Ecological comments

Planning Application No: **3/2012/0539**

Proposals: **Proposed installation of three endurance 50kw wind turbines 46m in overall height**

Location: **Carr Hall Garden Centre**

Figure 1: Proposed turbine locations (yellow markers)

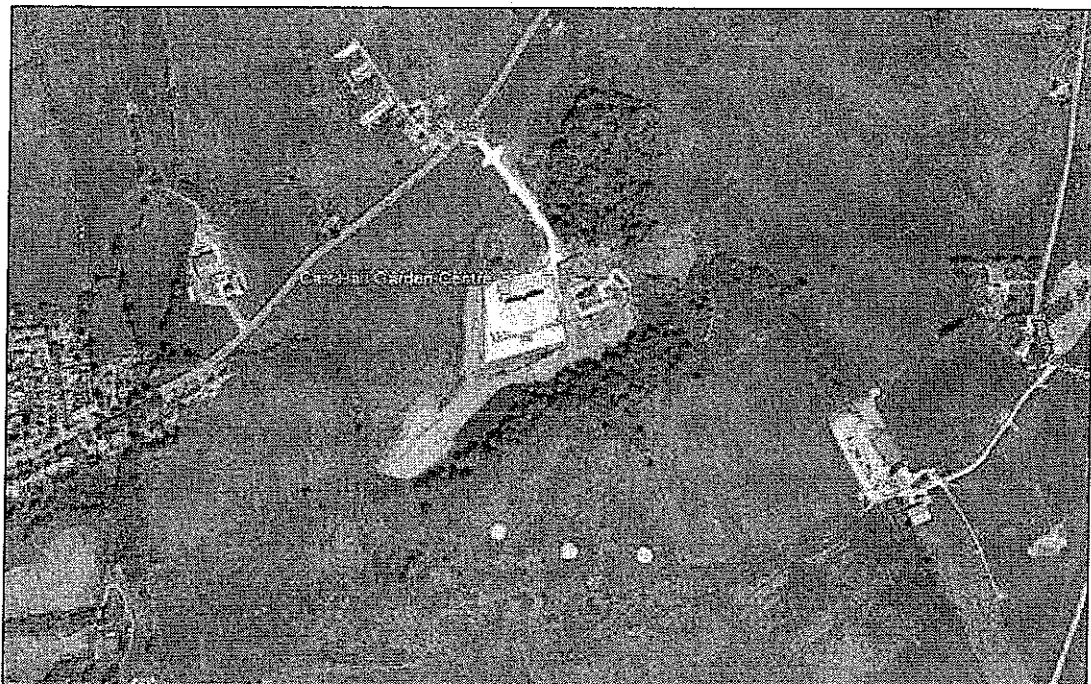
- Further surveys are required in order to assess likely impacts on bats. The field within which the turbines are to be sited has potential to be of value to foraging bats (para 3.3, ecology report) and therefore bats may be impacted by the installation of turbines. Bat activity surveys should be carried out in order to assess the use of this field by bats and to assess the likely impacts on bats. If impacts are likely, then mitigation measures should be submitted and the Ribbles Valley Borough Council will need to have regard to the requirements of the Habitats Directive in reaching the planning decision.

- The ecology report does not mention any assessment of potential impacts on owls or raptors. Confirmation should be given that potential impacts on these species have been considered.
